APPLICANT'S RESPONSES TO RELEVANT REPRESENTATIONS AND ADDITIONAL SUBMISSIONS

Drax Bioenergy with Carbon Capture and Storage

Document Reference Number: 8.3

PINS Reference: EN010120

DRAWING NUMBER
EN010120-PA-ES-6.2.18.1-Sheet5

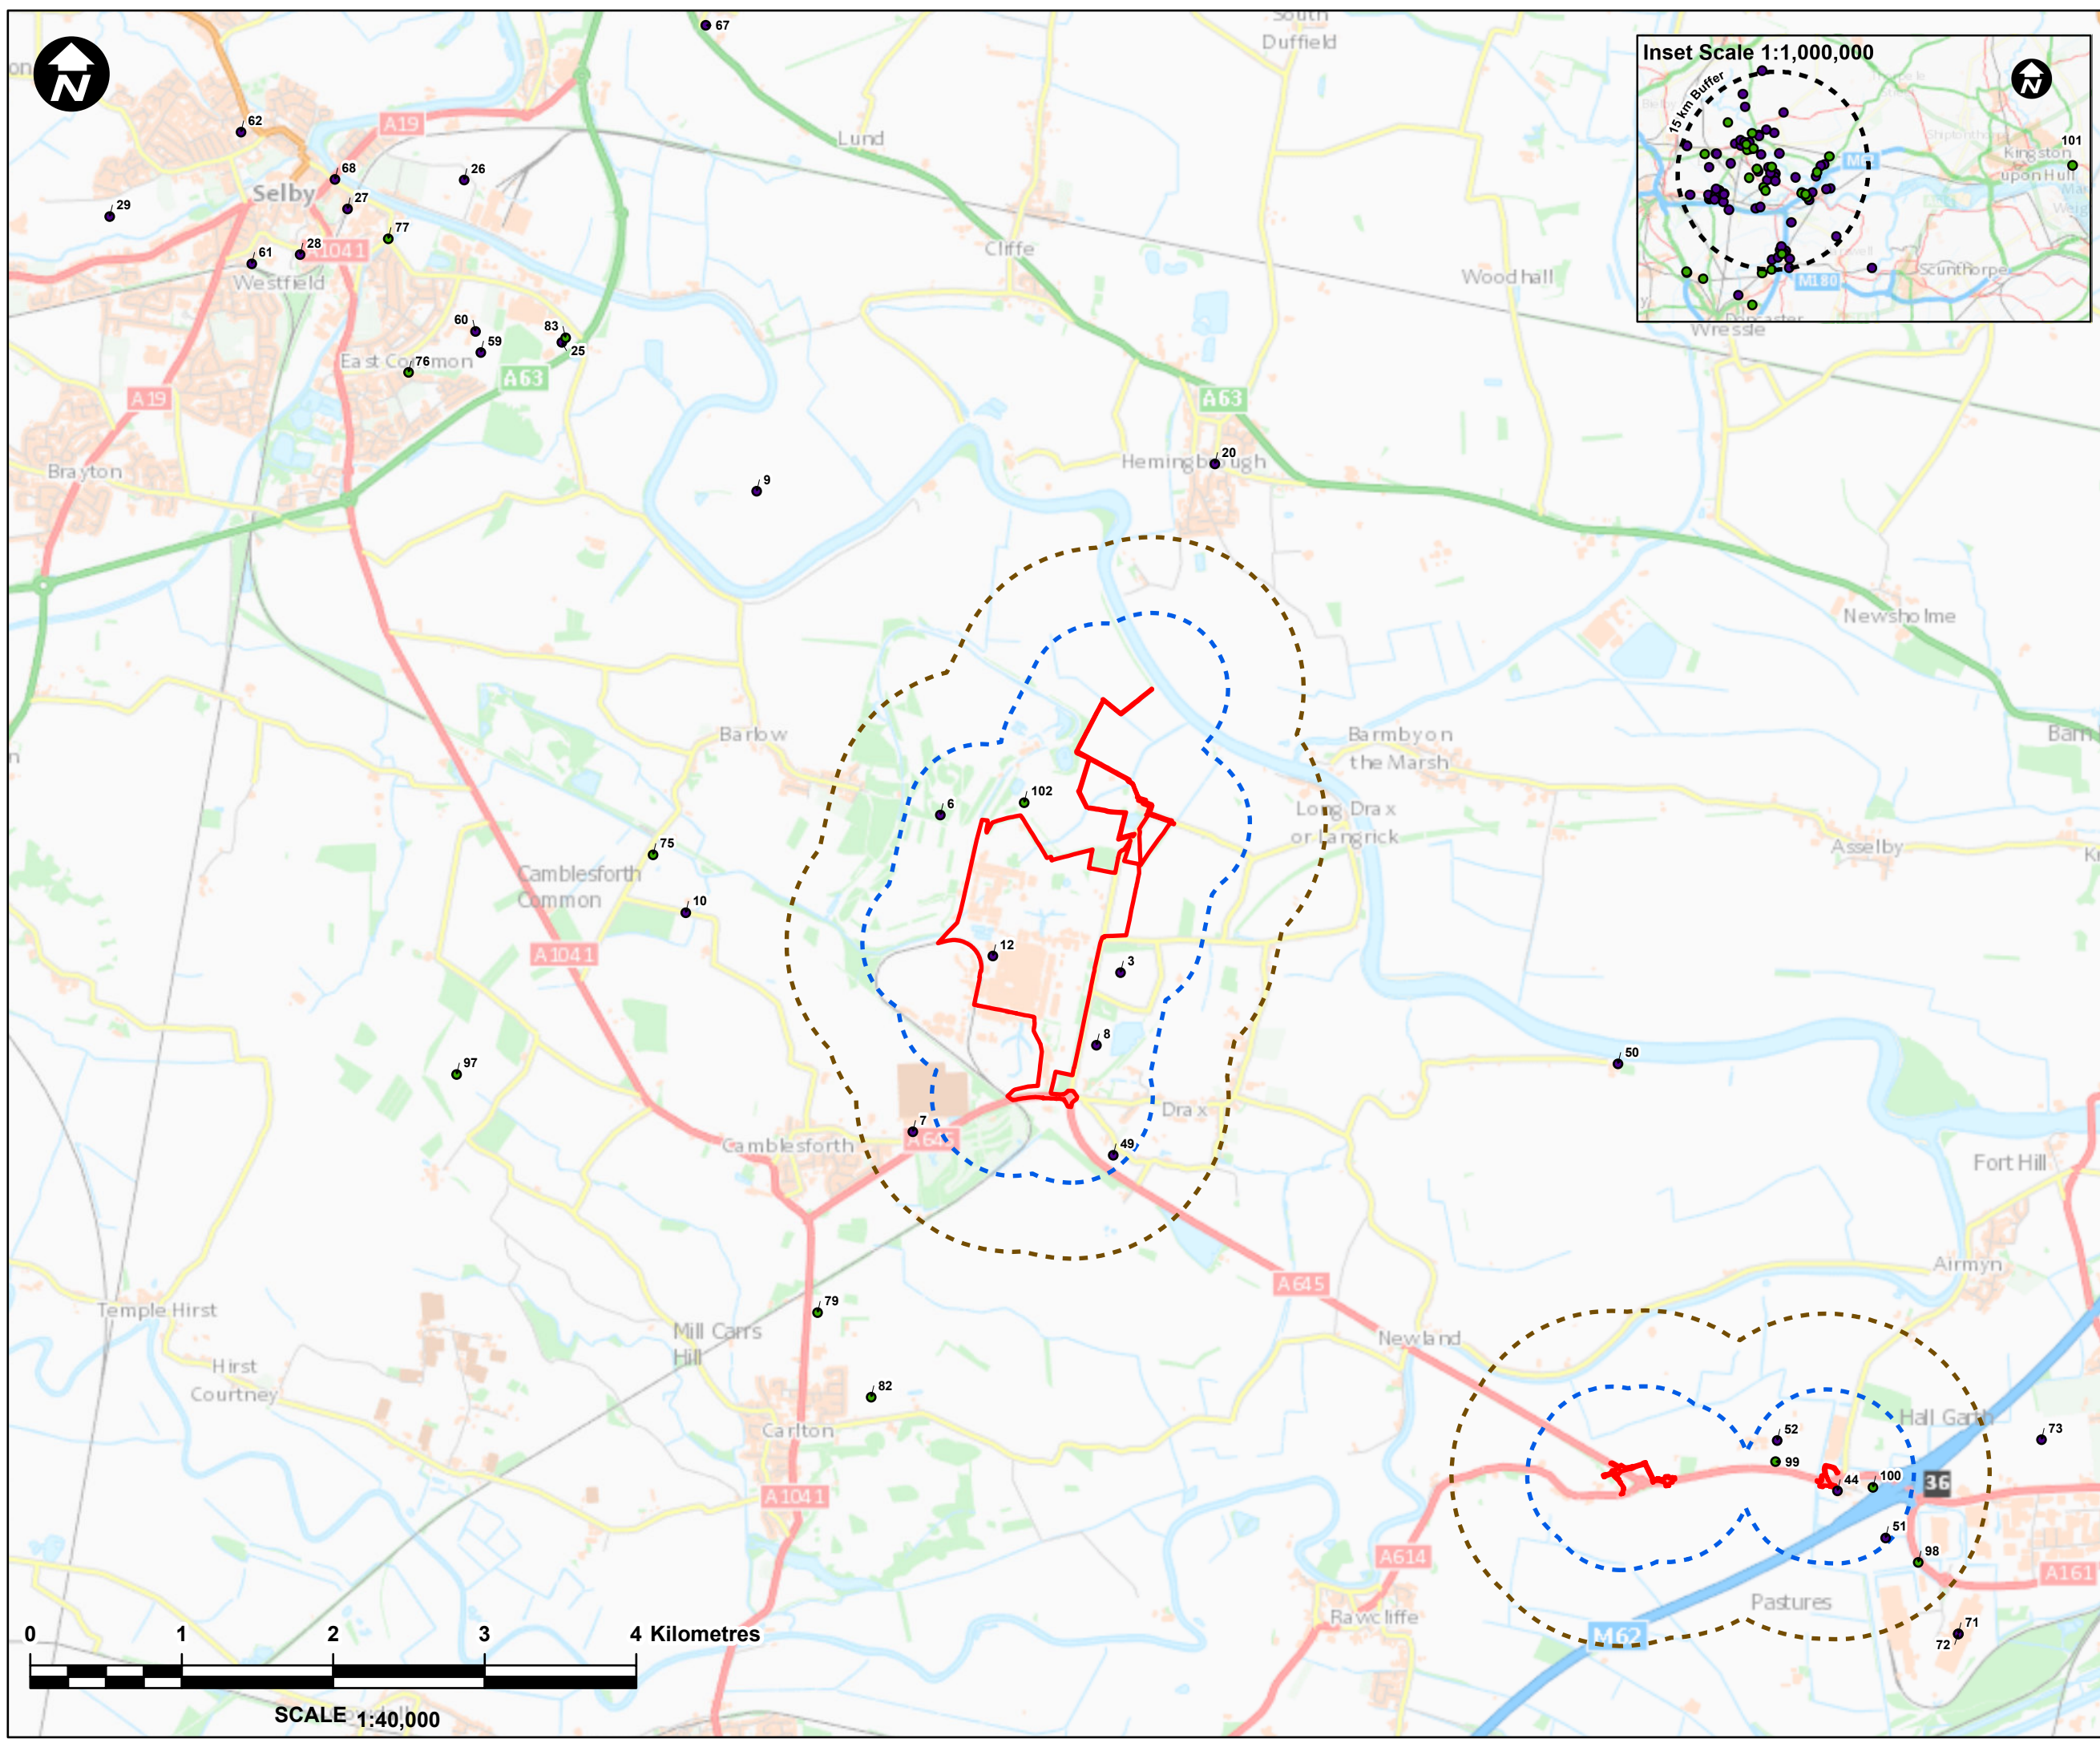
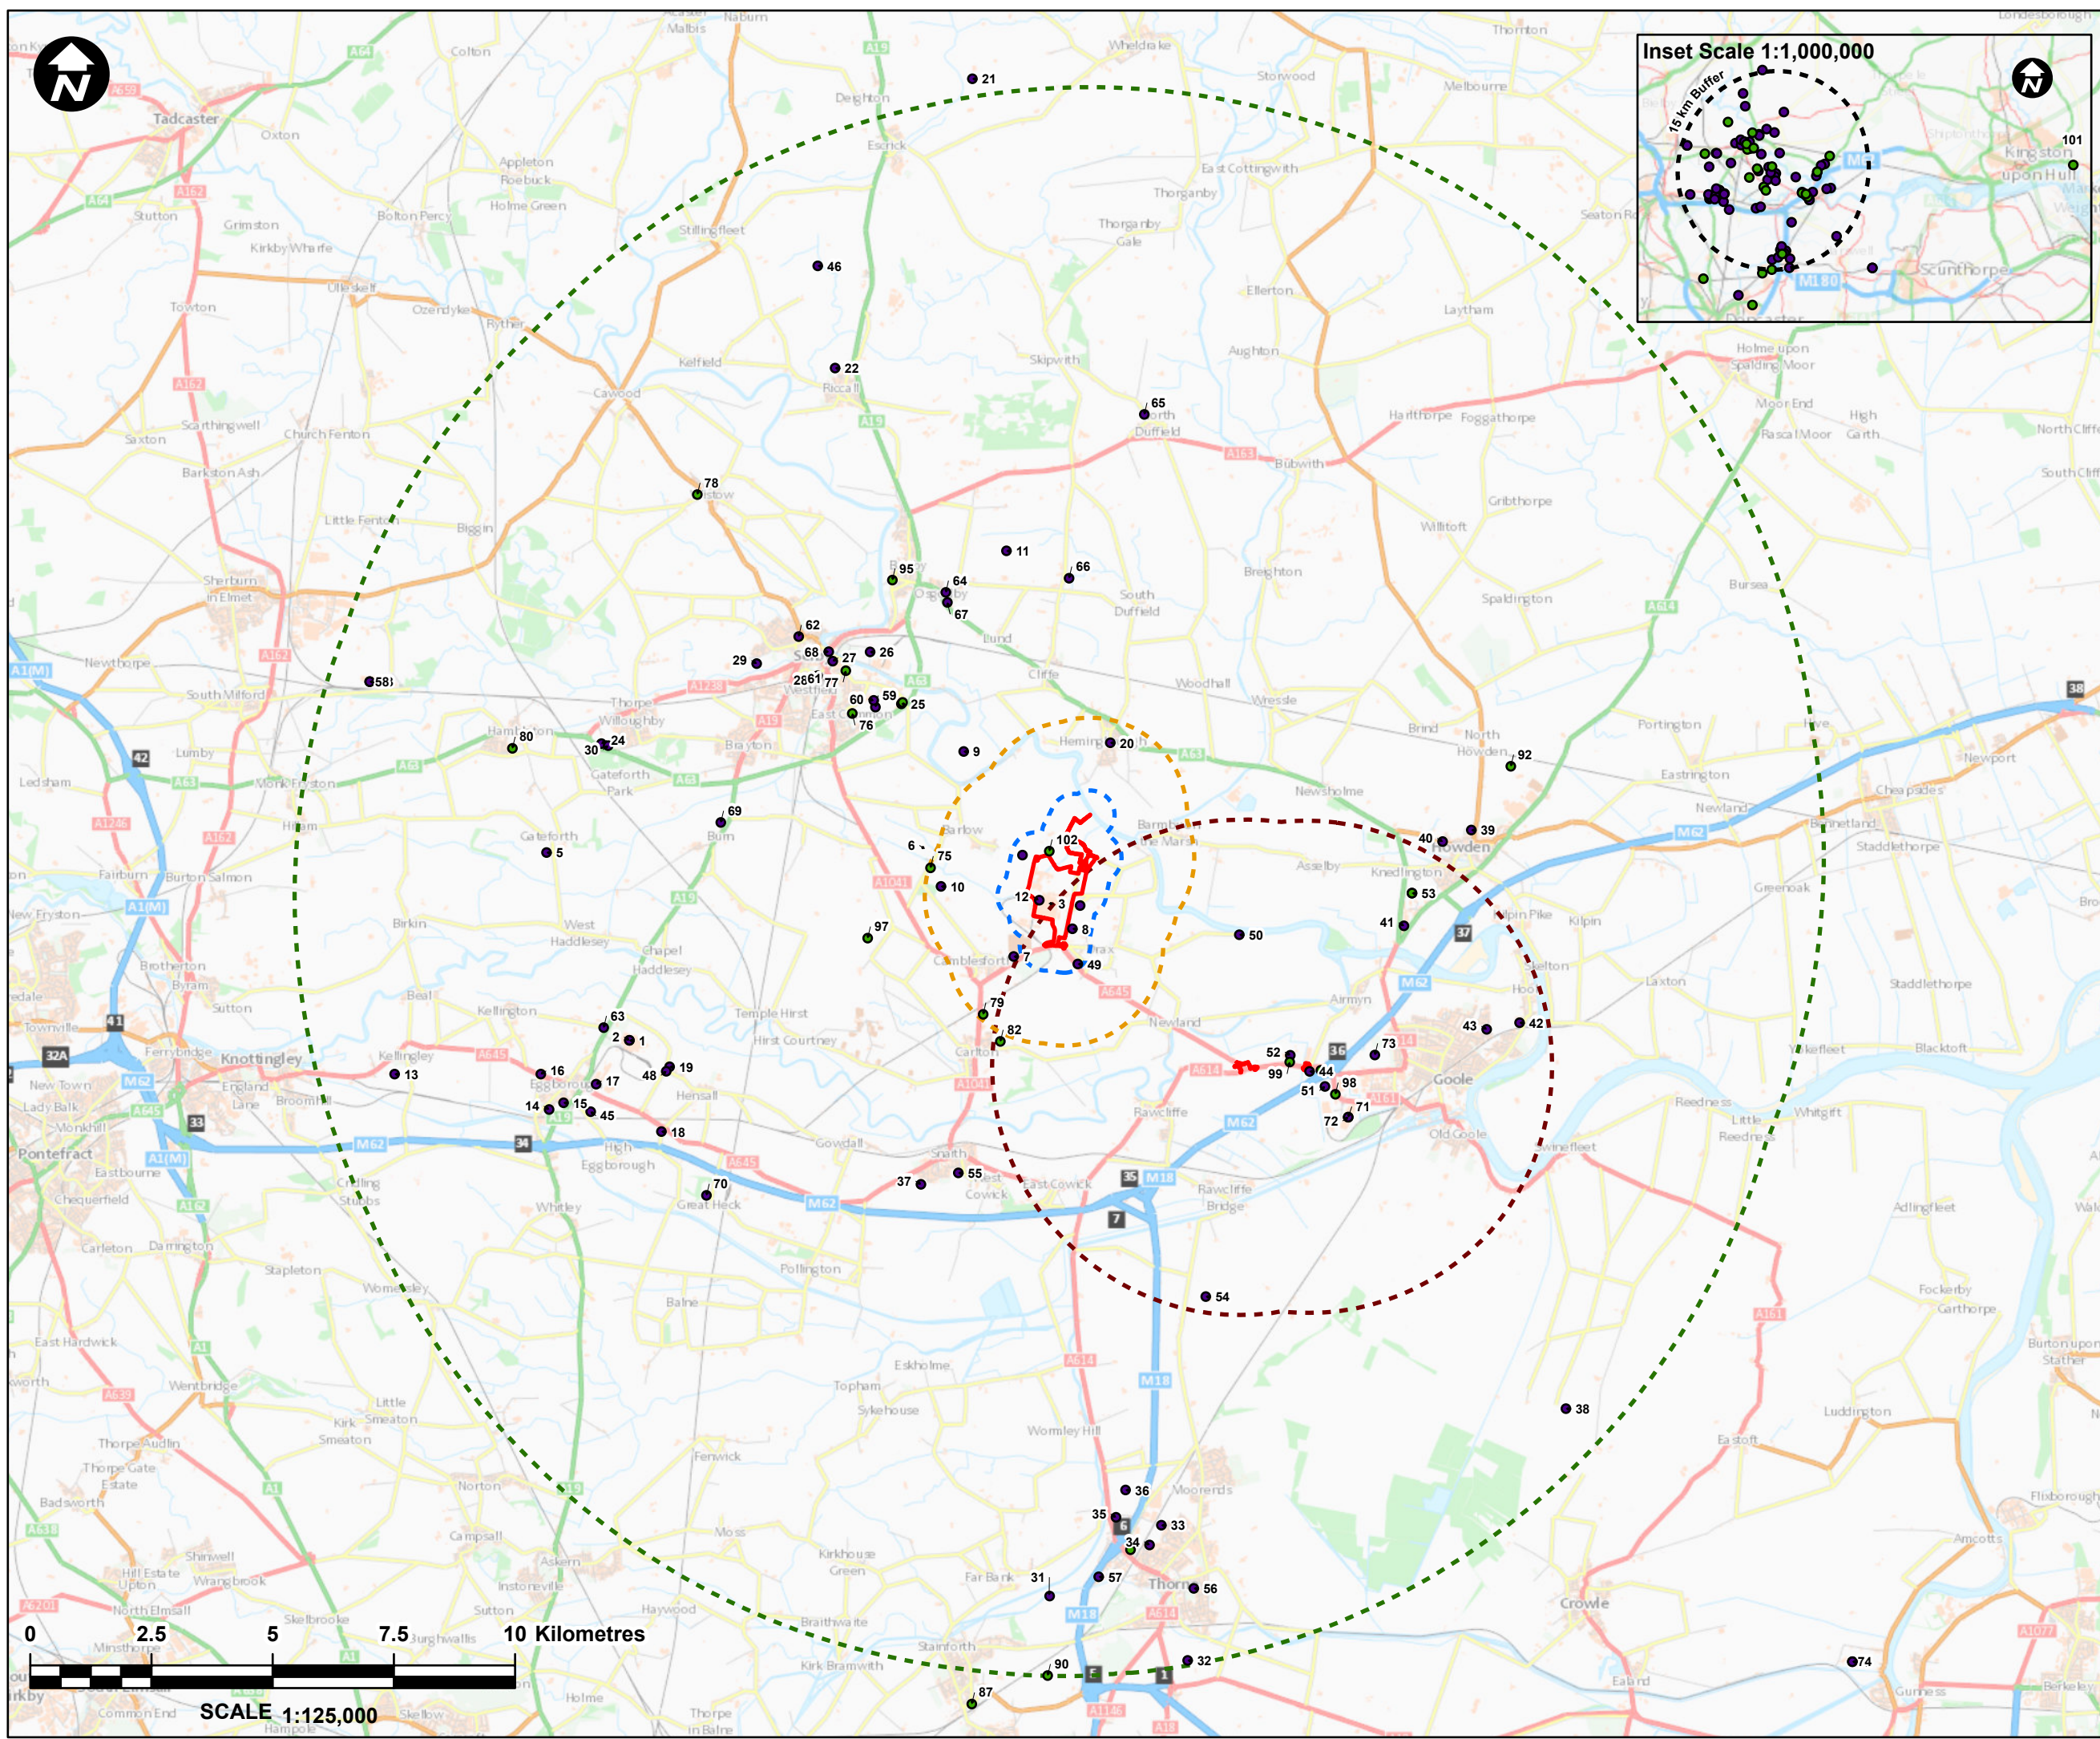
Response Ref.	Relevant Representation Comment	Applicant's Response
2.12. Cumulative	It has been noted that 6.3.18.2 Environmental Statement - Volume 3 - Appendix 18.2 'Short List of Other Developments' only contains 46 schemes, while the Environmental Statement refers to 76 schemes. It is understood that the applicant is aware of this issue and is looking to issue a corrected version for consideration.	This comment is noted and it is confirmed that the formatting error has been amended and a new version was issued to NYCC/SDC and other consultees on 1 September 2022. The updated document was reissued to PINS on 7 October 2022 (AS-013).
